**Re: NuVue at 1171 Jaffa Rd. NE  
Erosion and Sediment Control Plan  
Engineer's Stamp Date 2/29/24 (L22E011)**

Based upon the information provided in your submittal received on 3/4/24, the above-referenced ESC Plan can't be approved until the following comments are addressed. Generally, the SWPPP (SWPPP maps and ESC Plans) must be prepared in accordance with good engineering practices by qualified (e.g., CPESC-certified, engineers with appropriate training) erosion control specialists per CGP 9.6.1.c.iii. You must implement erosion and sediment controls in accordance with the requirements of CGP 2.2 to minimize the discharge of pollutants in stormwater from construction activities.

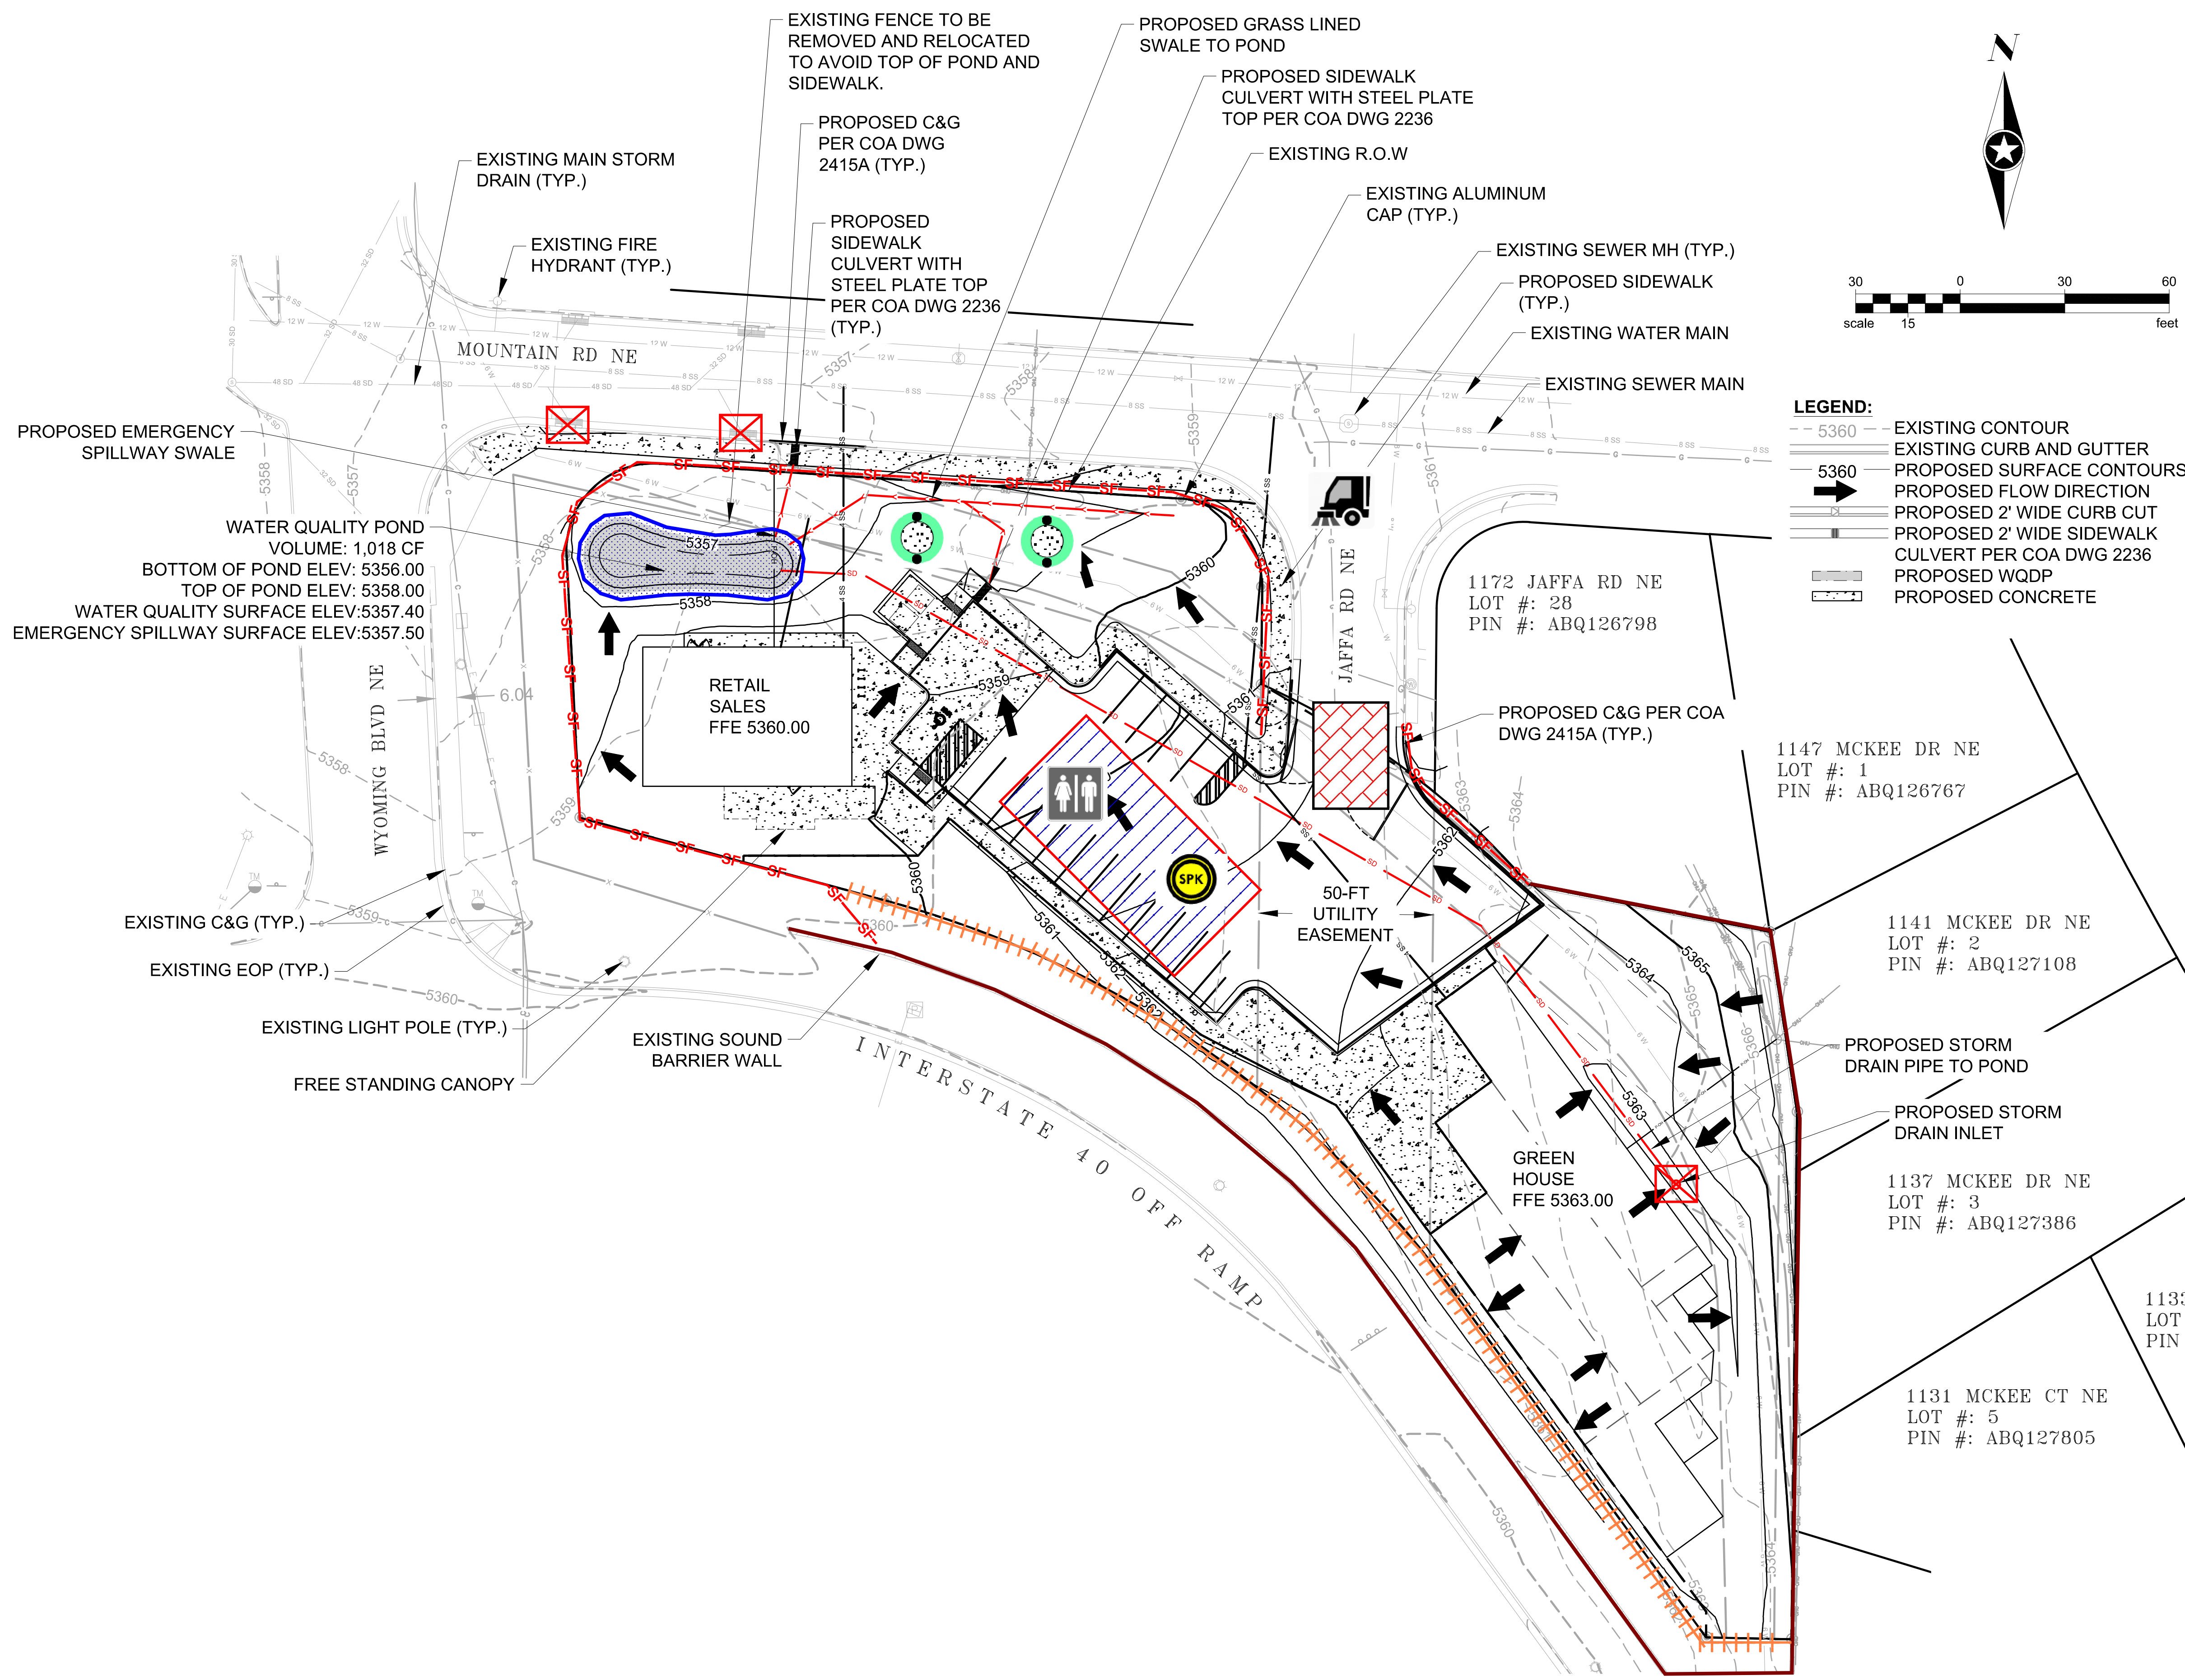
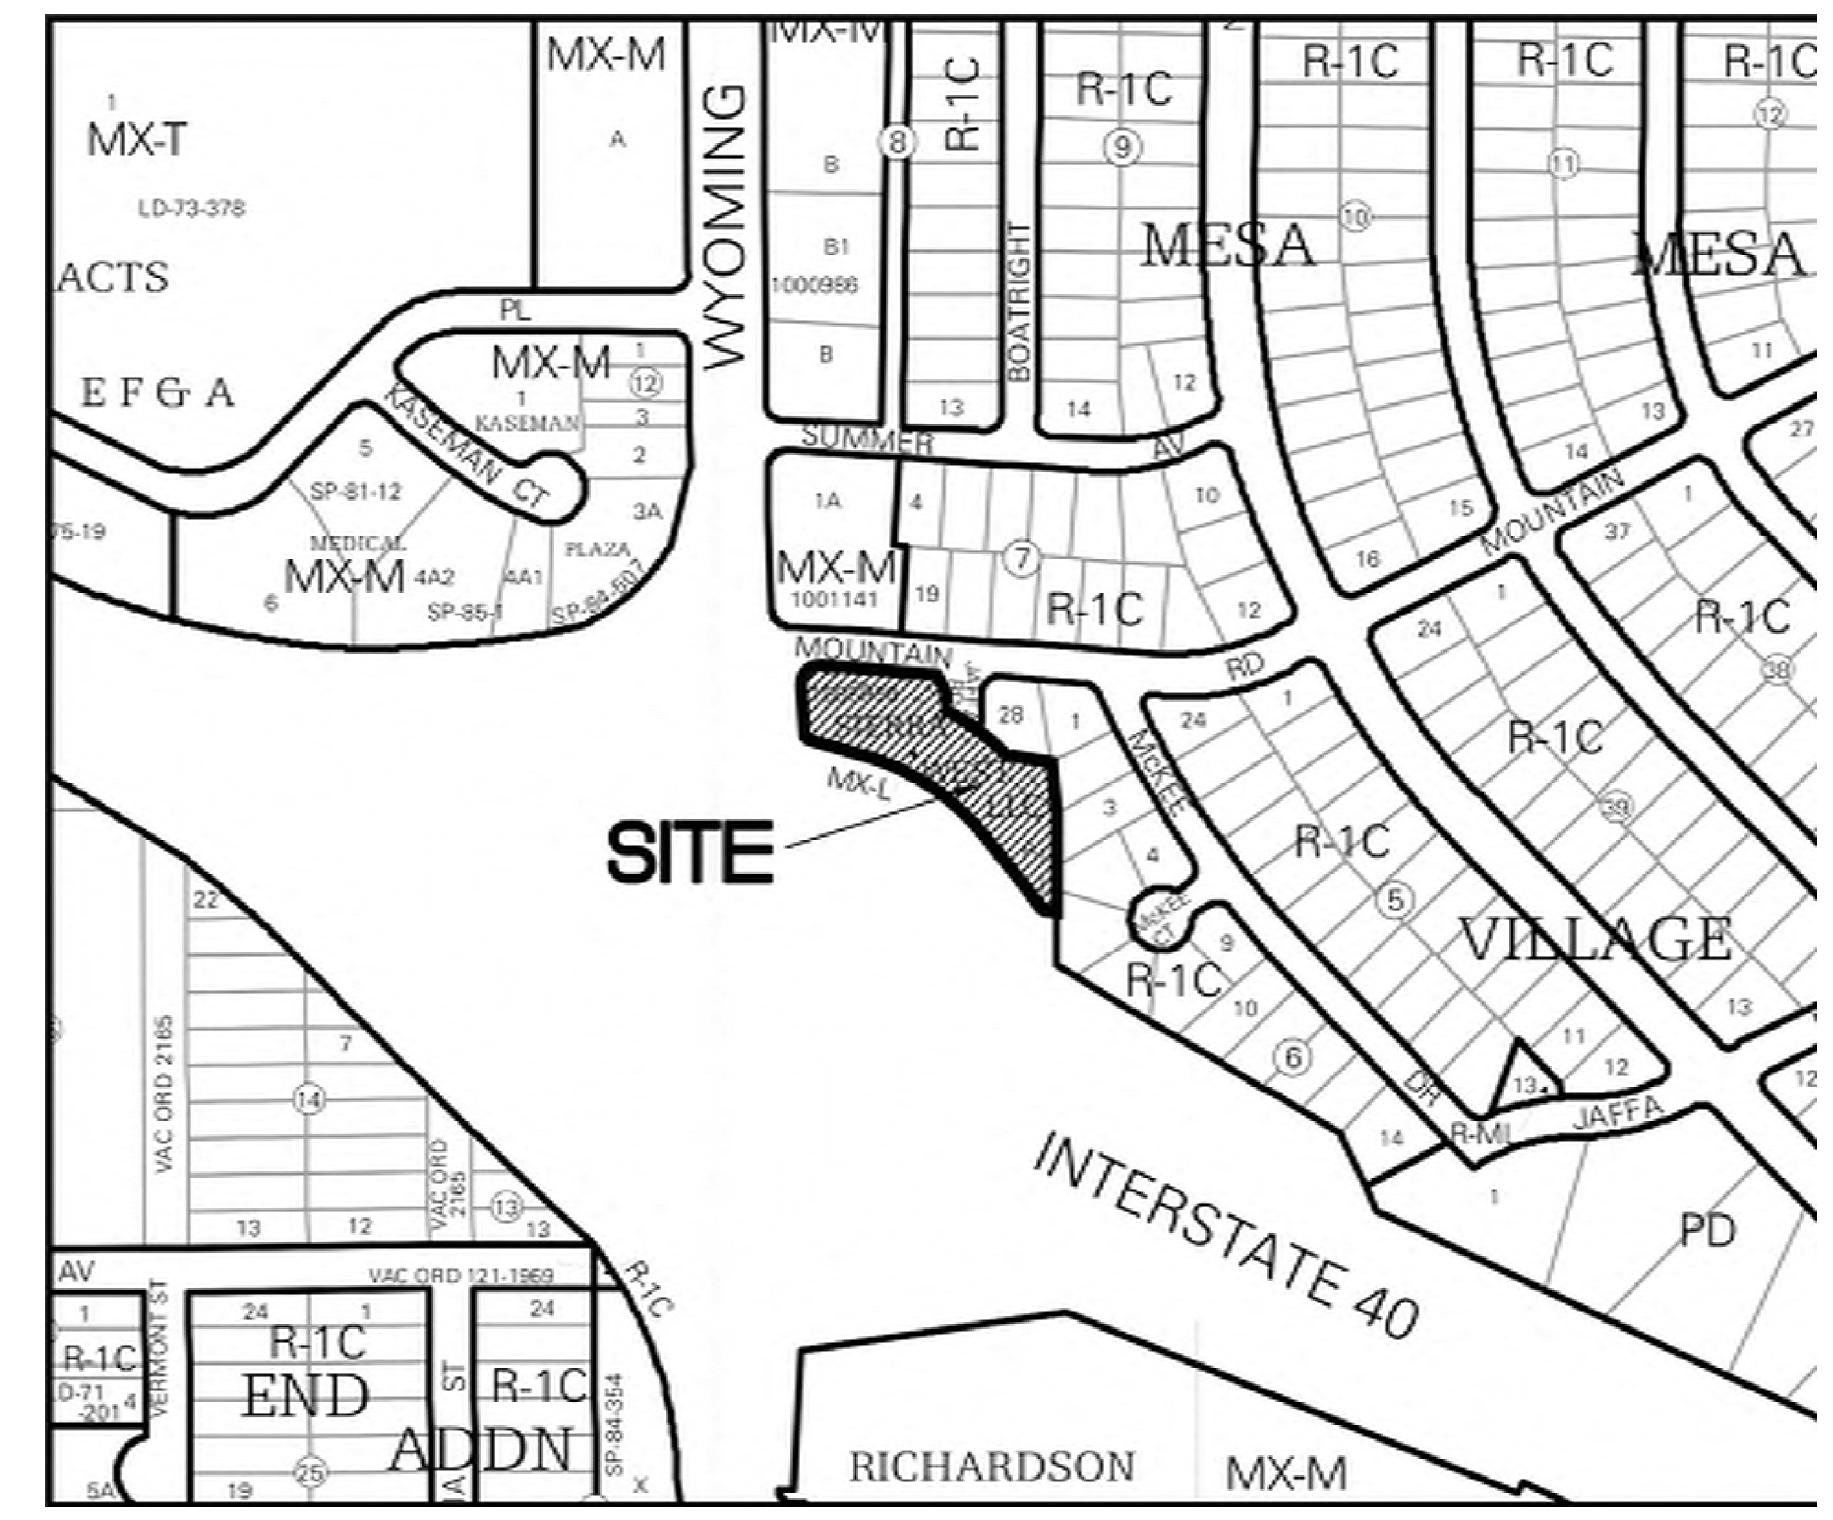
2. Since the construction specifications are missing, it isn't clear what is meant by "Stabilized Asphalt Entrance" on the ESC Plan, but it seems unlikely that it will provide the required sediment removal from vehicles prior to their exit from the site onto the paved portion of Jaffa Rd. per as required by CGP 2.2.4.

4. The Limits of Disturbance is not identified on the ESC Plan and must be added per CGP 7.2.4.b.i. It must include all frontage improvements, such as sidewalks and landscaping within the adjacent Right of Way.

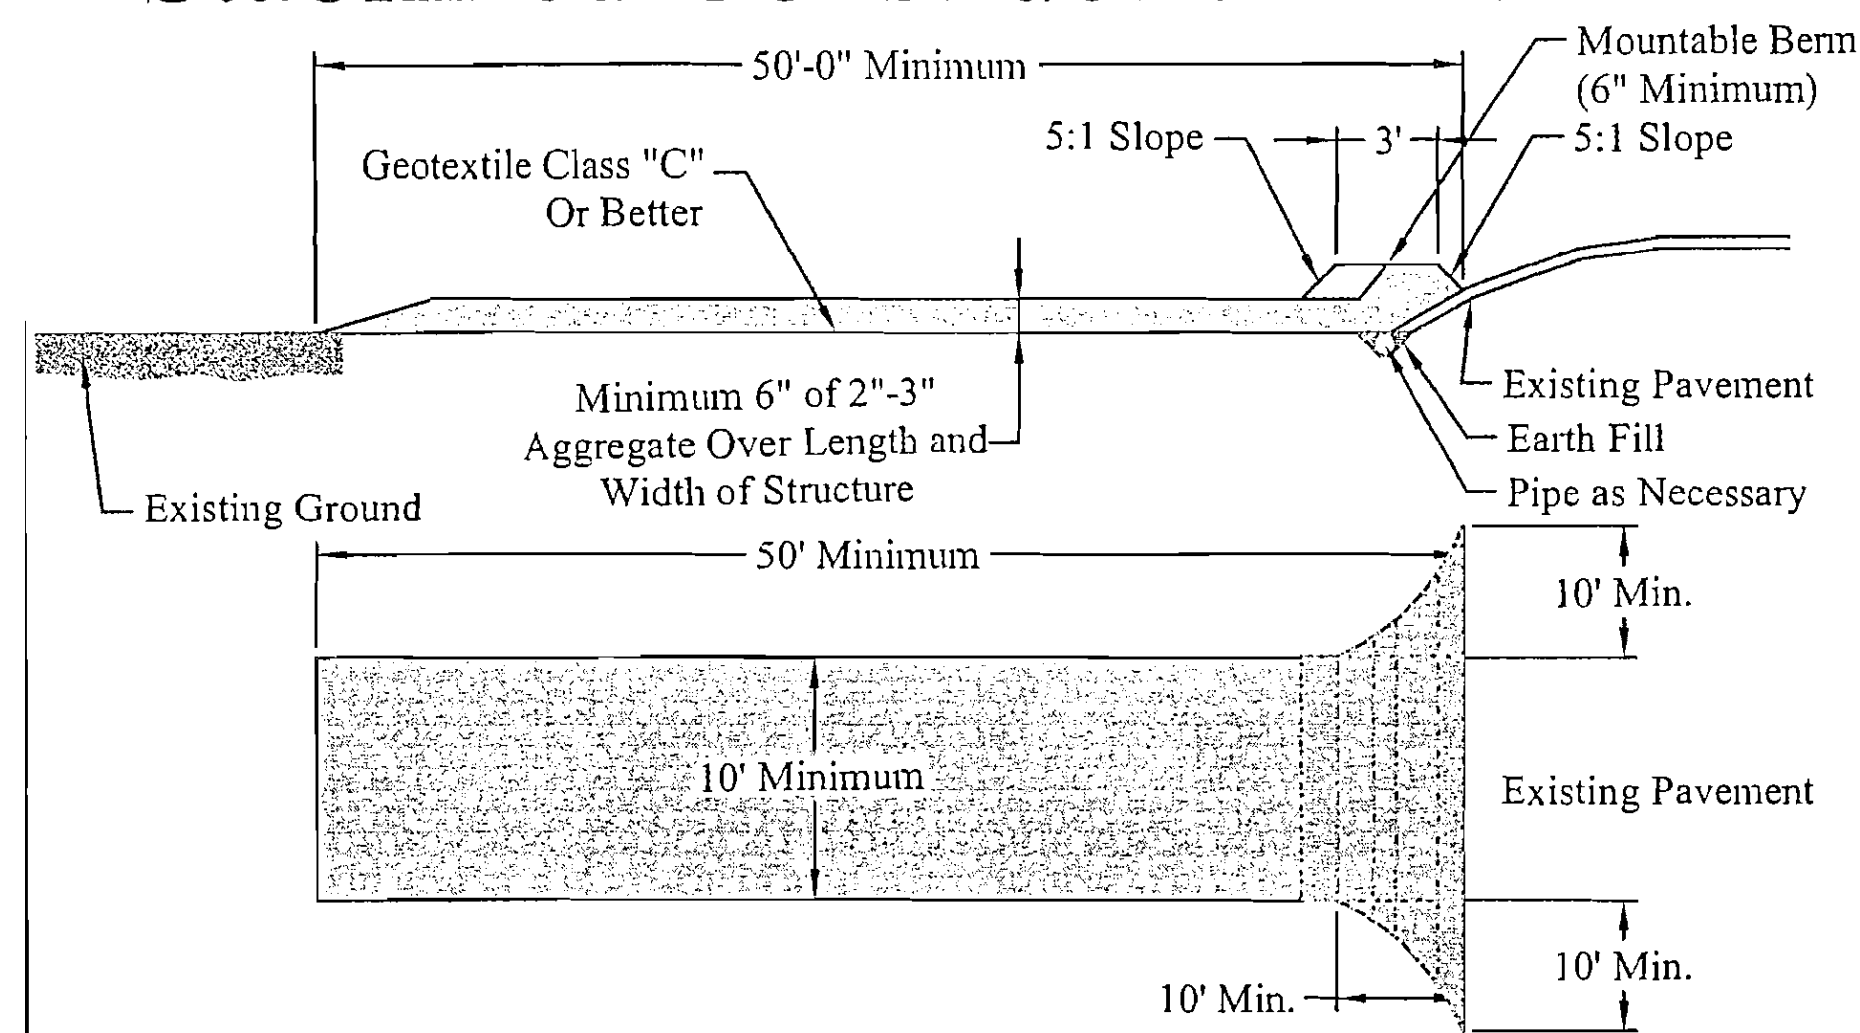
1. The SWPPP must describe design specifications, construction specifications, maintenance schedules (including a long-term maintenance plan), criteria for inspections, and expected performance and longevity of these BMPs per CGP 9.6.1.c.i. The construction specifications must be included with the ESC application to the SWQ Section, preferably on one of the sheets in the ESC Plan per the attached ESC Plan Checklist.
